Yorkshire Green Energy Enablement (GREEN) Project

**Document 8.28 Applicant's Comments on Interested Parties' Deadline
5 Submissions**

**Final Issue A
July 2023**

Planning Inspectorate Reference: EN020024

PLAN VIEW 2
SCALE 1:250

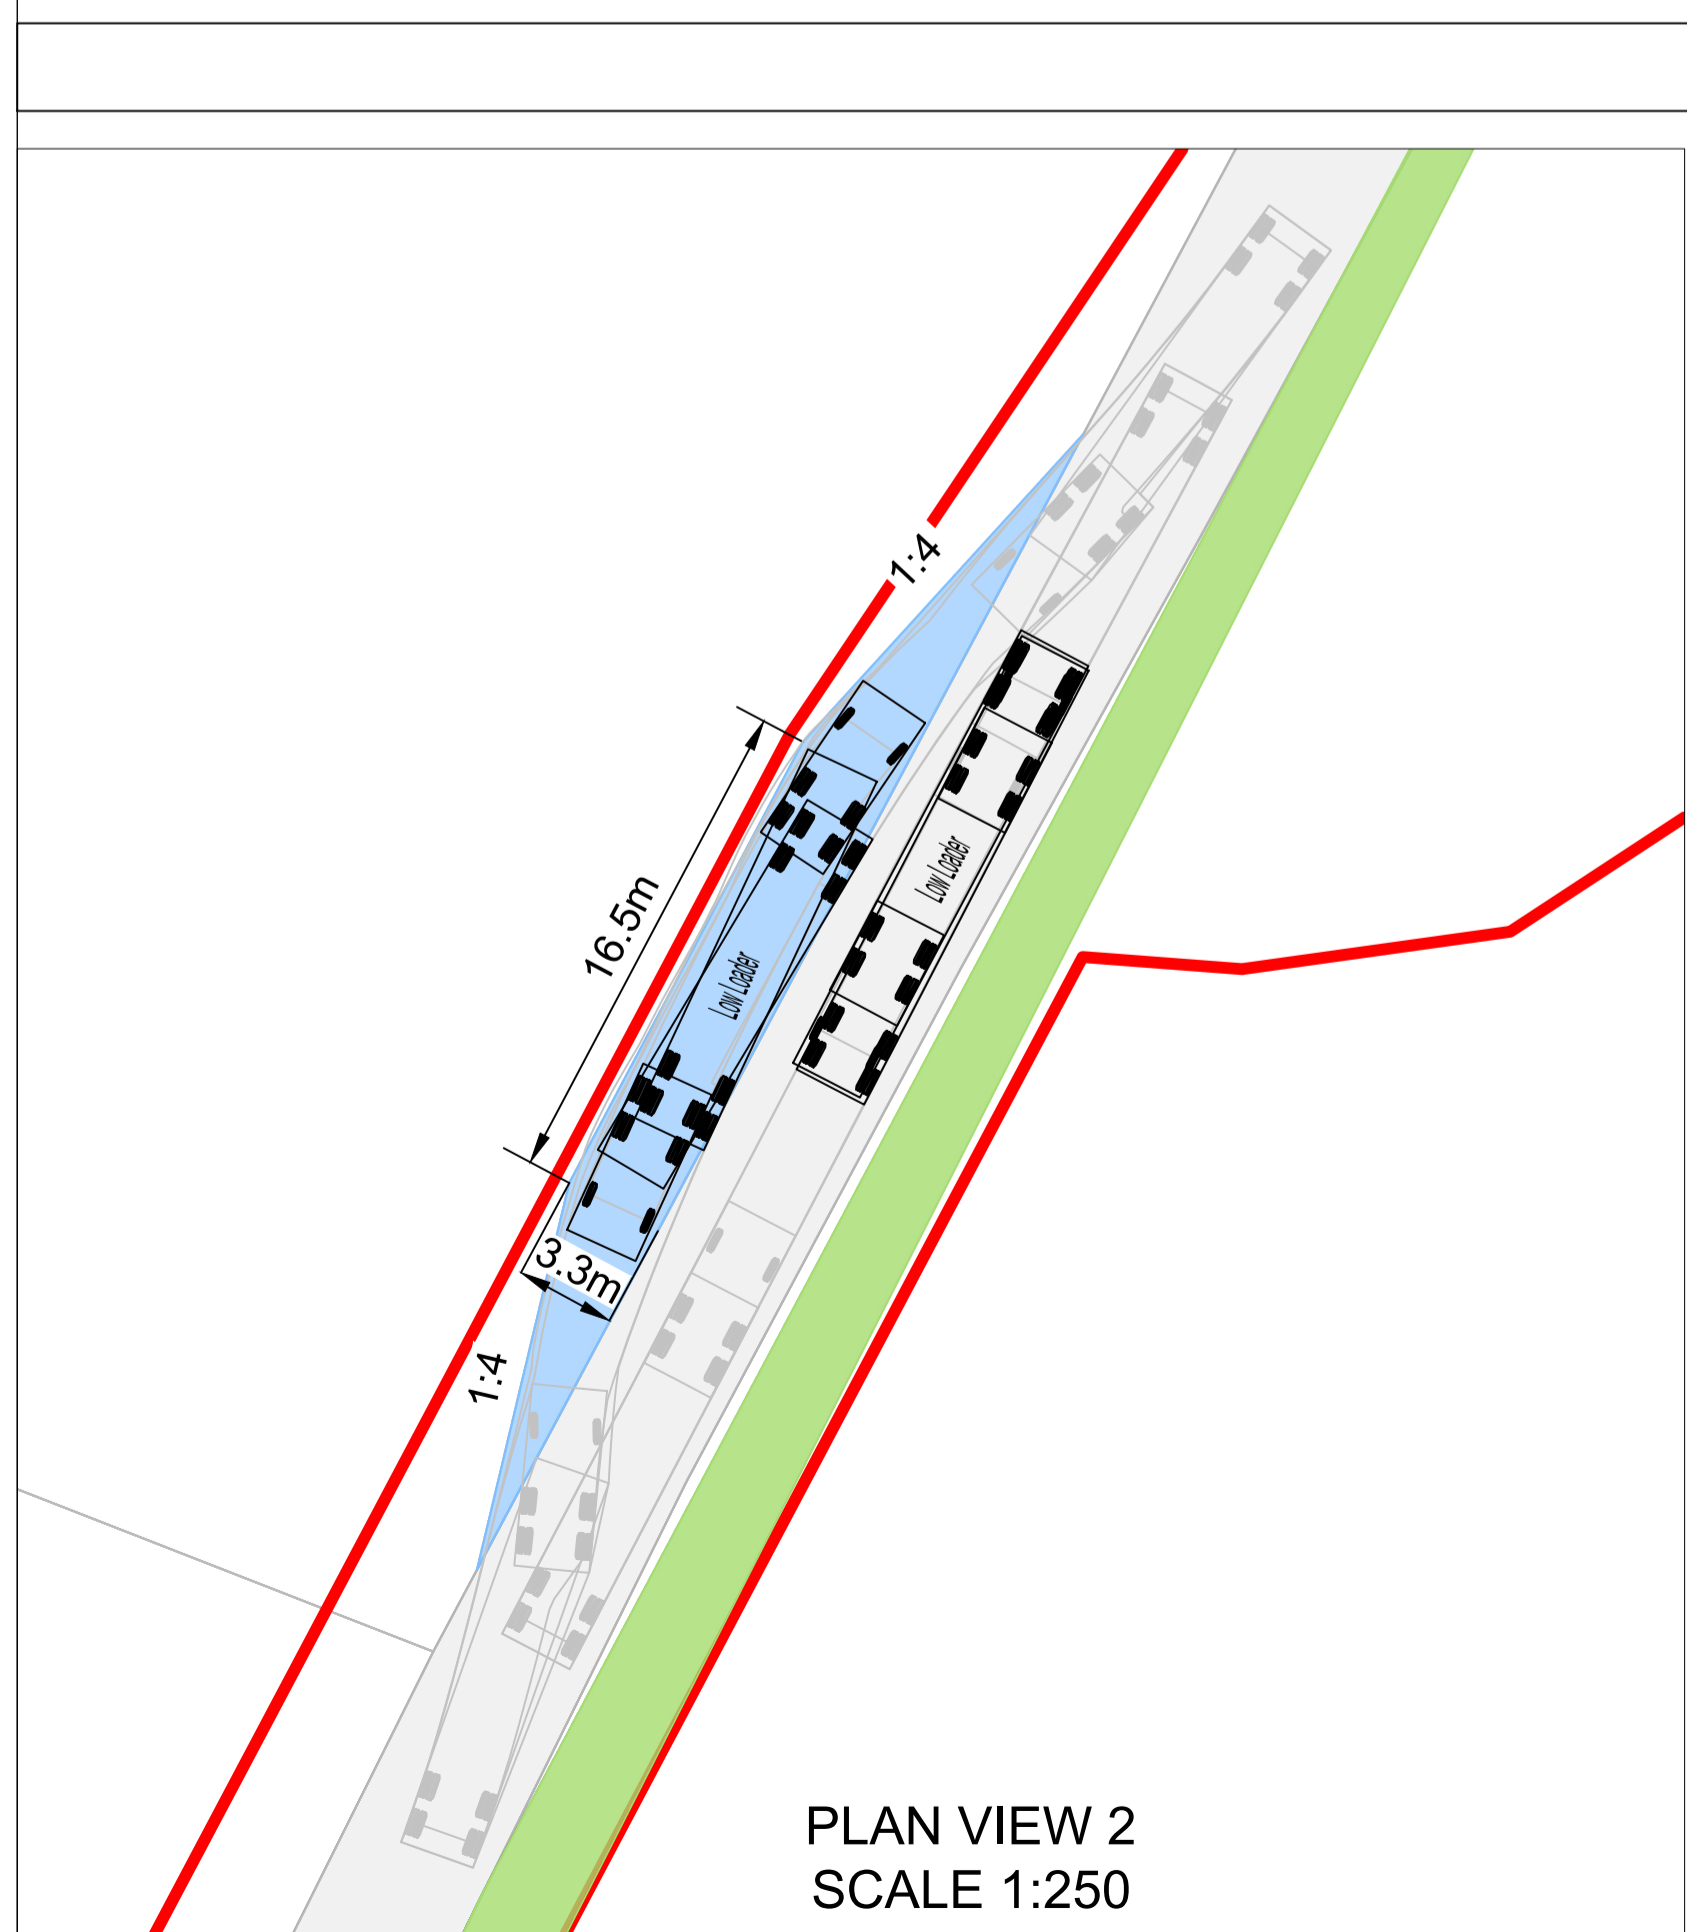
Reference	Topic	Applicant’s Response
Q1.3.2	Illustrative Plan: SP005 Access During Construction Phase [REP4-026], Appendix D	<p>National Grid seeks to clarify that the plan submitted within Appendix D of [REP4-026] was intended to illustrate potential access road passing places only and was not intended for any other purpose.</p> <p>However, in response to the comments received from City of York Council (CYC) (stating that detailed construction drawings will be required [REP5-101]), National Grid confirms that engagement between both parties is ongoing, and as per the Statement of Common Ground (Document 8.5.4(C)) [REP5-033] there are no outstanding issues between the parties relating to transport matters.</p> <p>For clarification purposes, for any proposed accesses in the CYC area there will be consultation at the detailed design phase between National Grid and CYC, and this will include the production of detailed drawings.</p> <p>Requirement 14 of the Draft DCO (Document 3.1(D)) [REP5-004] details that construction of vehicular access cannot commence until the access layout and design has been submitted to and approved by the local highway authority. The Local Highway Authority will have the ability to control the required Licence or Agreement arrangements as part of this process.</p>
